Subject: Care Home at Pound Place, Roundstone Lane, Angmering Application no. A51/18/PL

My colleague Murray Chrystal has sent you a set of updated amended plans reducing the scheme in a number of different ways, together with a reduction in bedrooms, from 71 to 64. The purpose of this email is to highlight the nature of these changes in order to assist your consideration of the application.

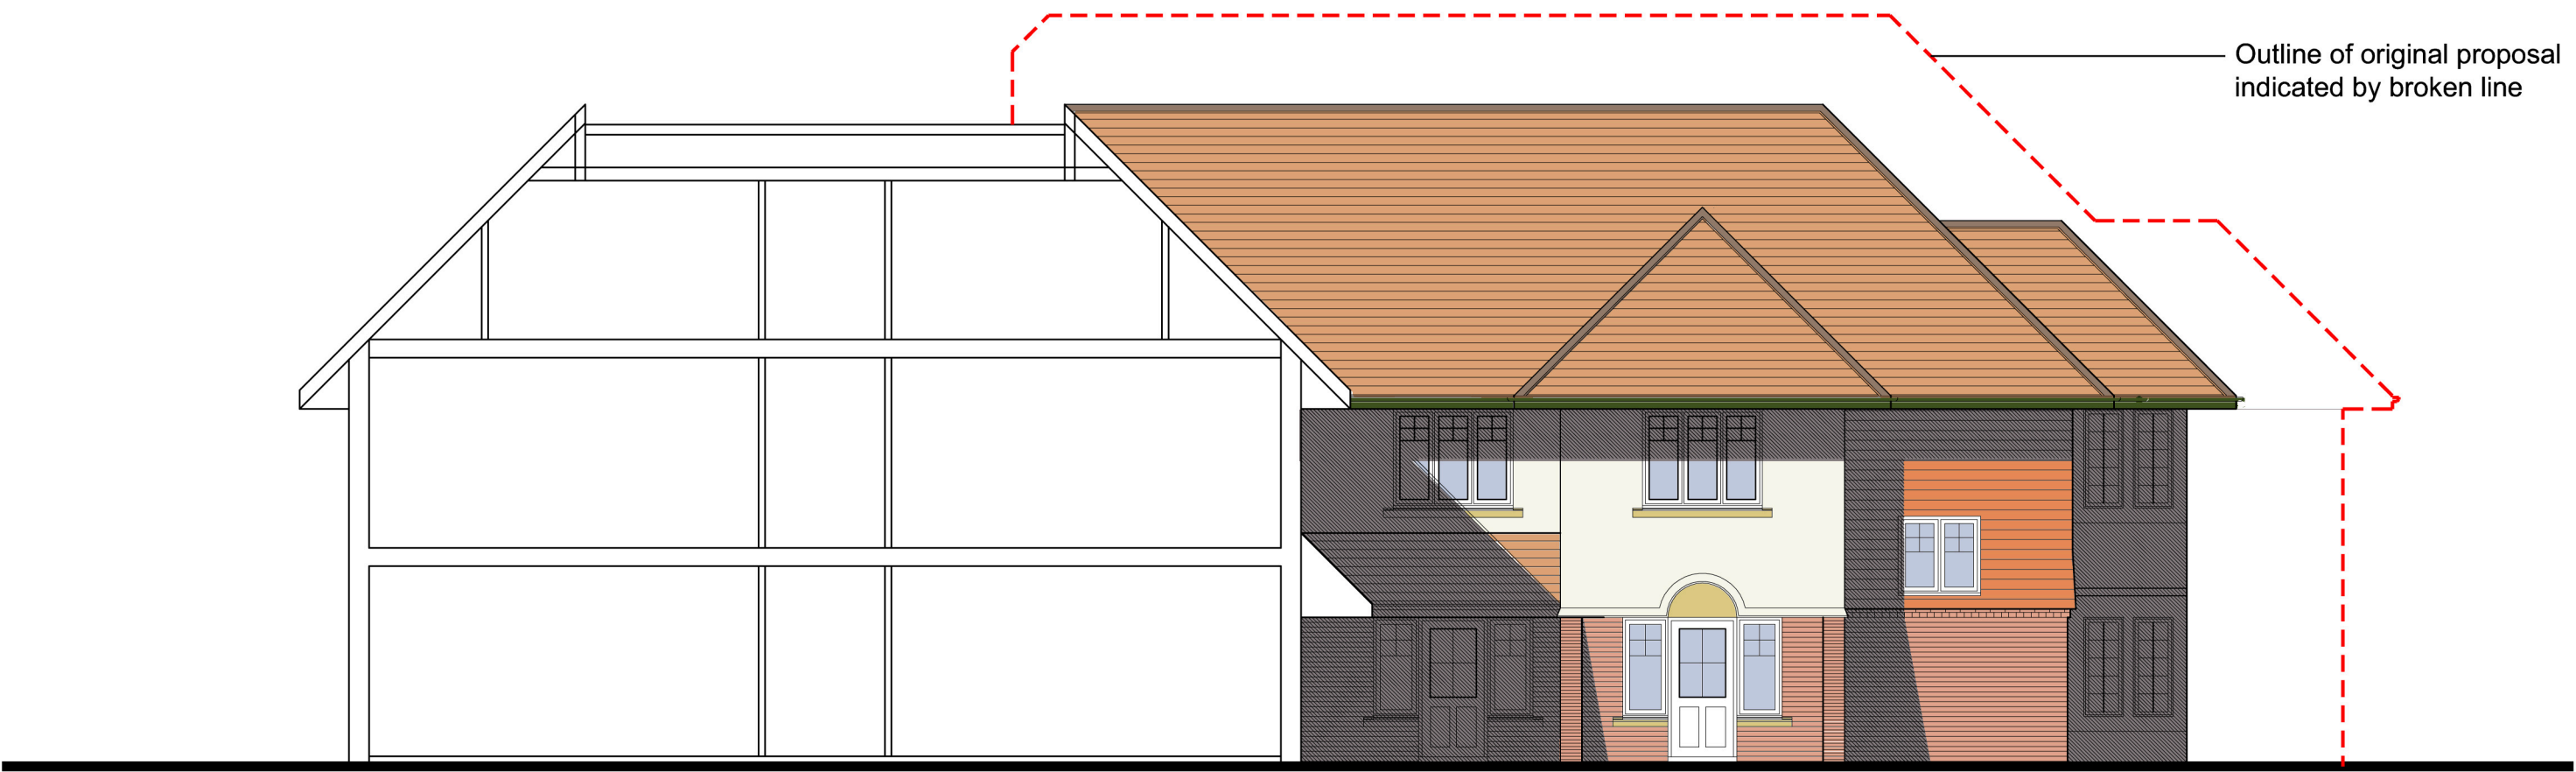
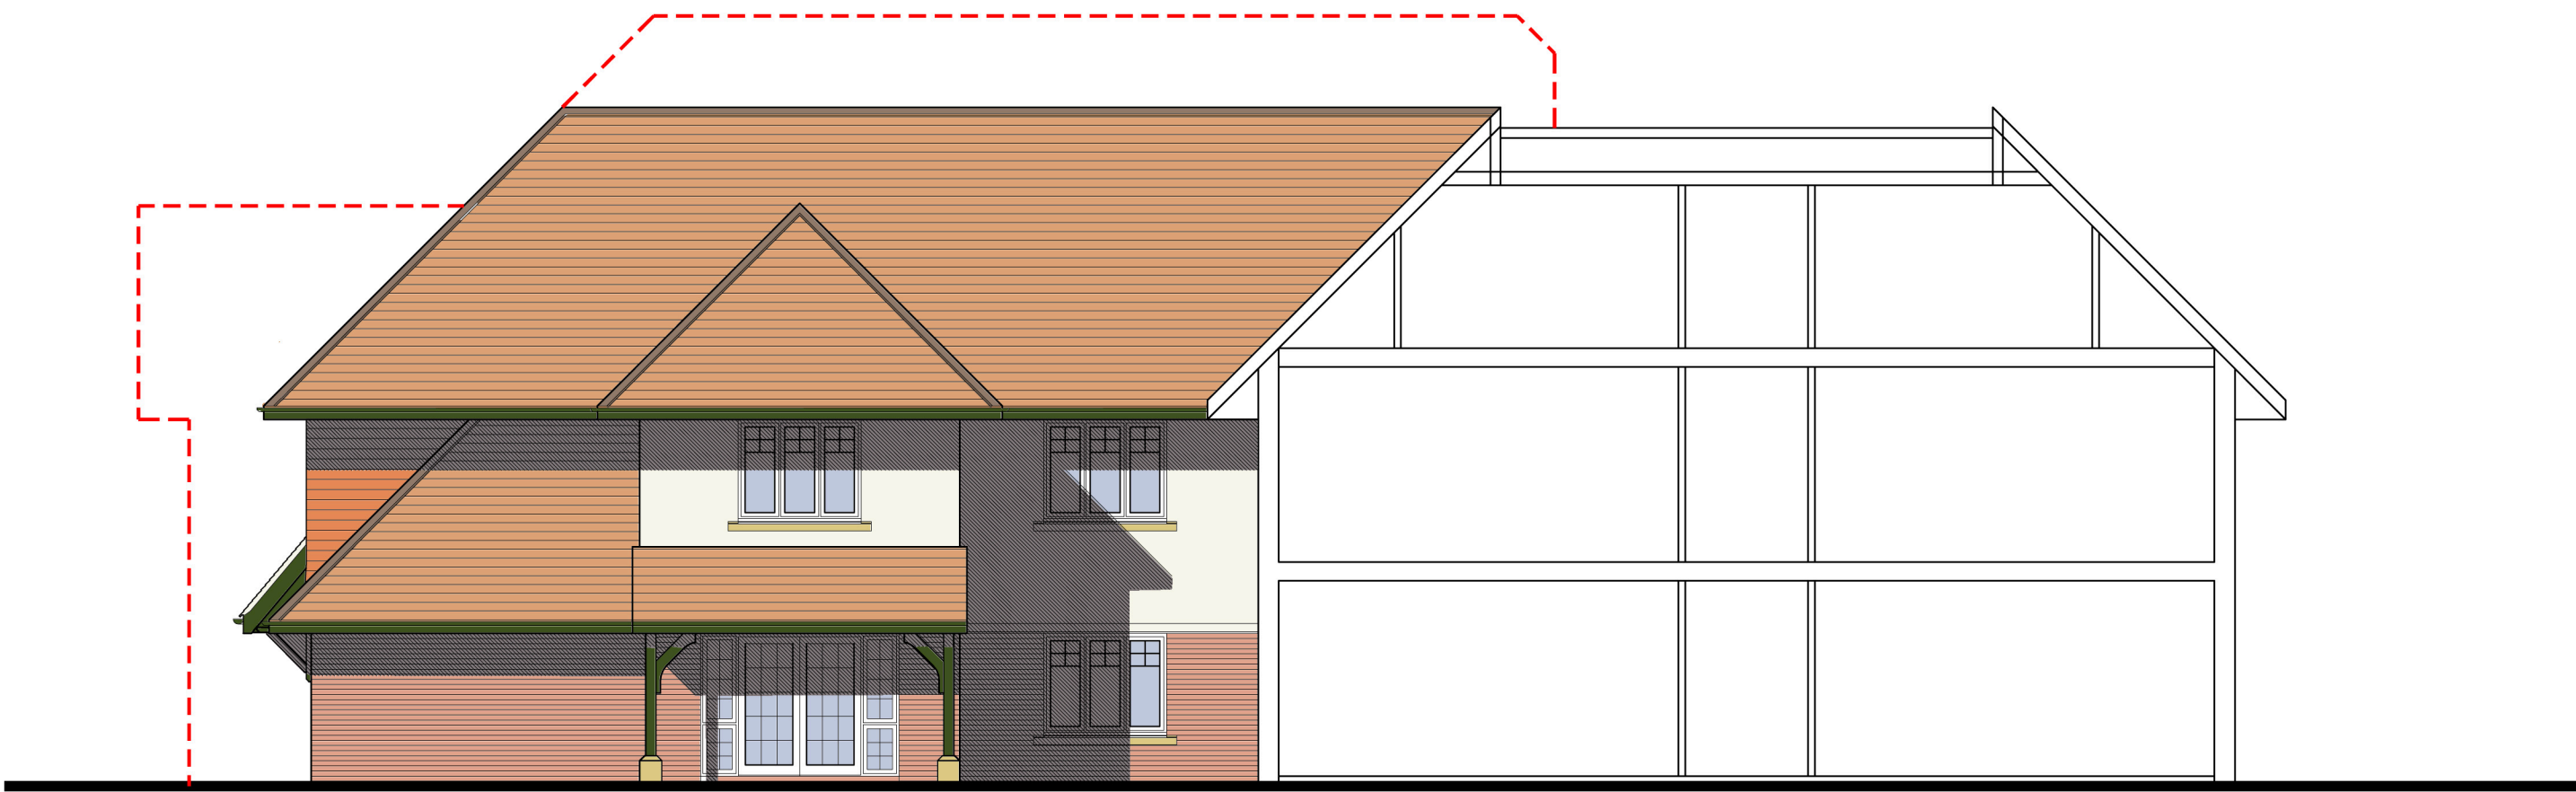
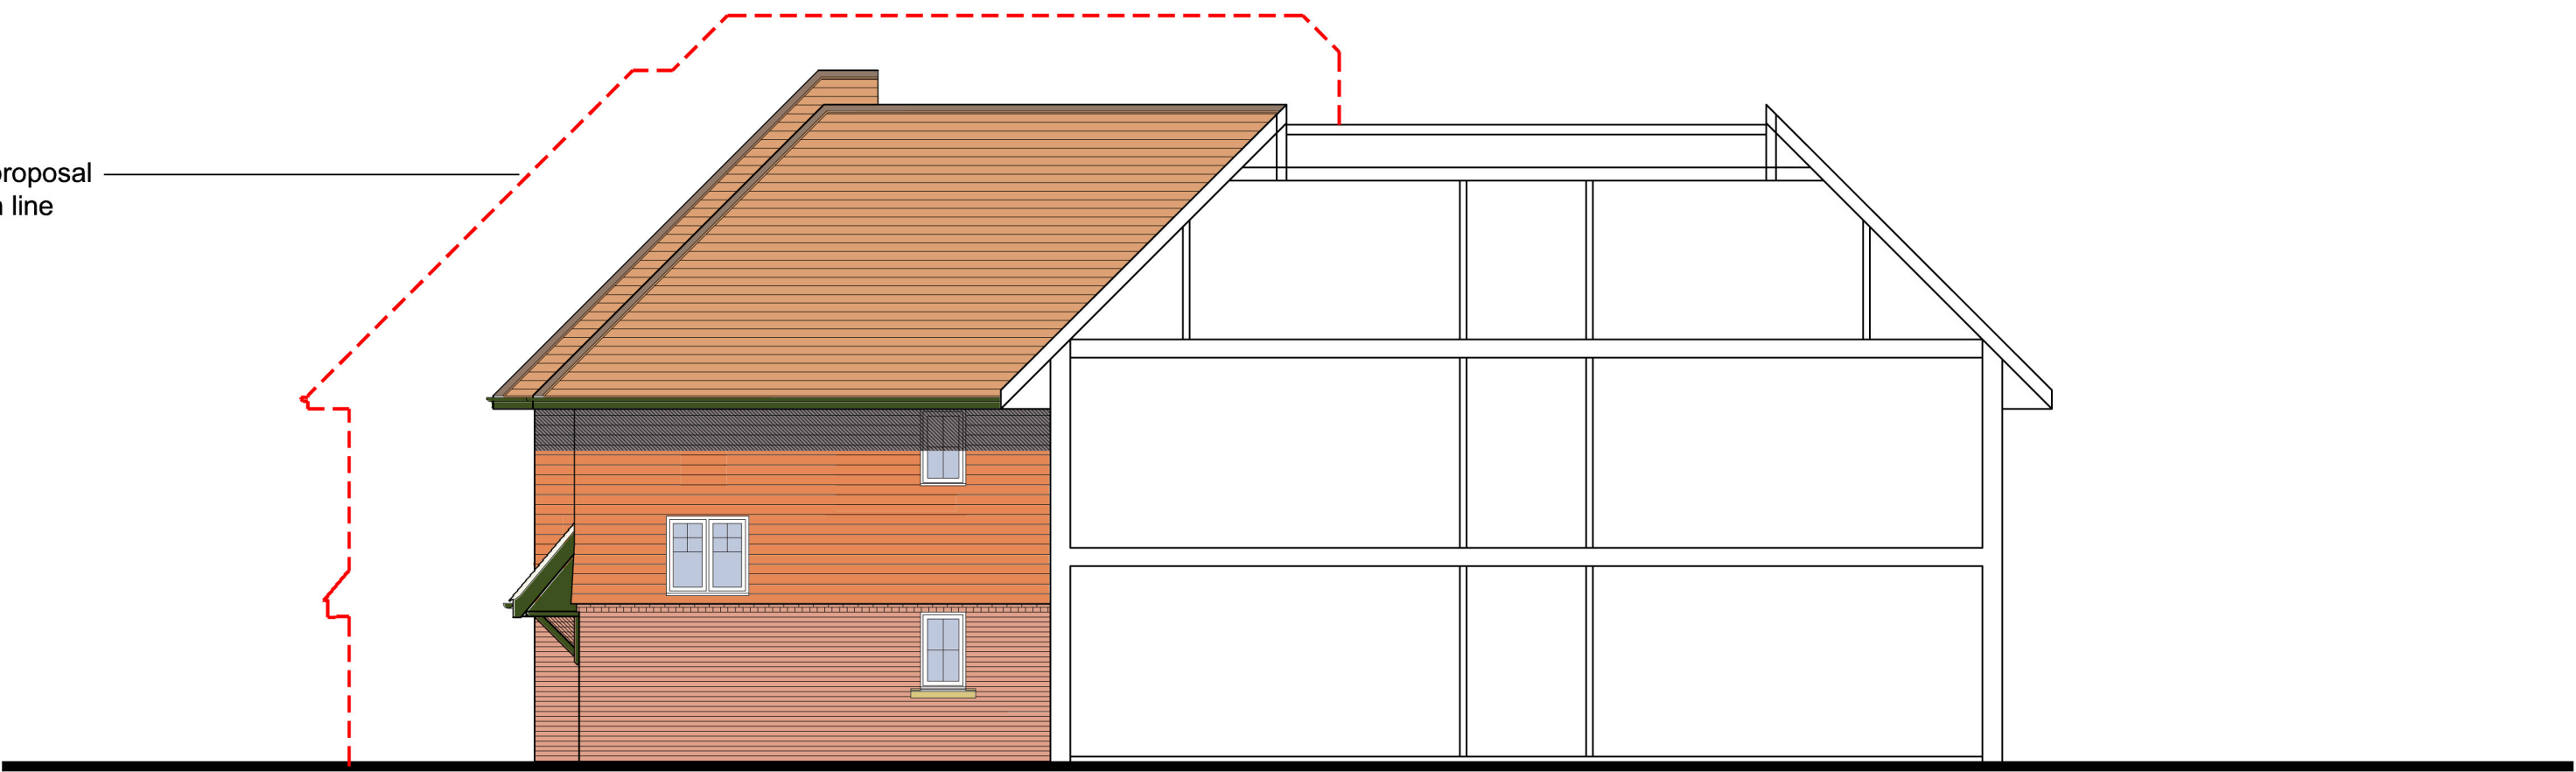
The amendments respond to the comments received following a review by a design consultant. There is a suggestion that the proposal, as submitted, is too large, in particular due to the height and massing of the roof. The amended scheme reduces the massing and height of the roof. This is evident from the plans which show by reference to a red dashed line the height and profile of the originally submitted scheme. It is therefore clear how this amended scheme has responded to this point.
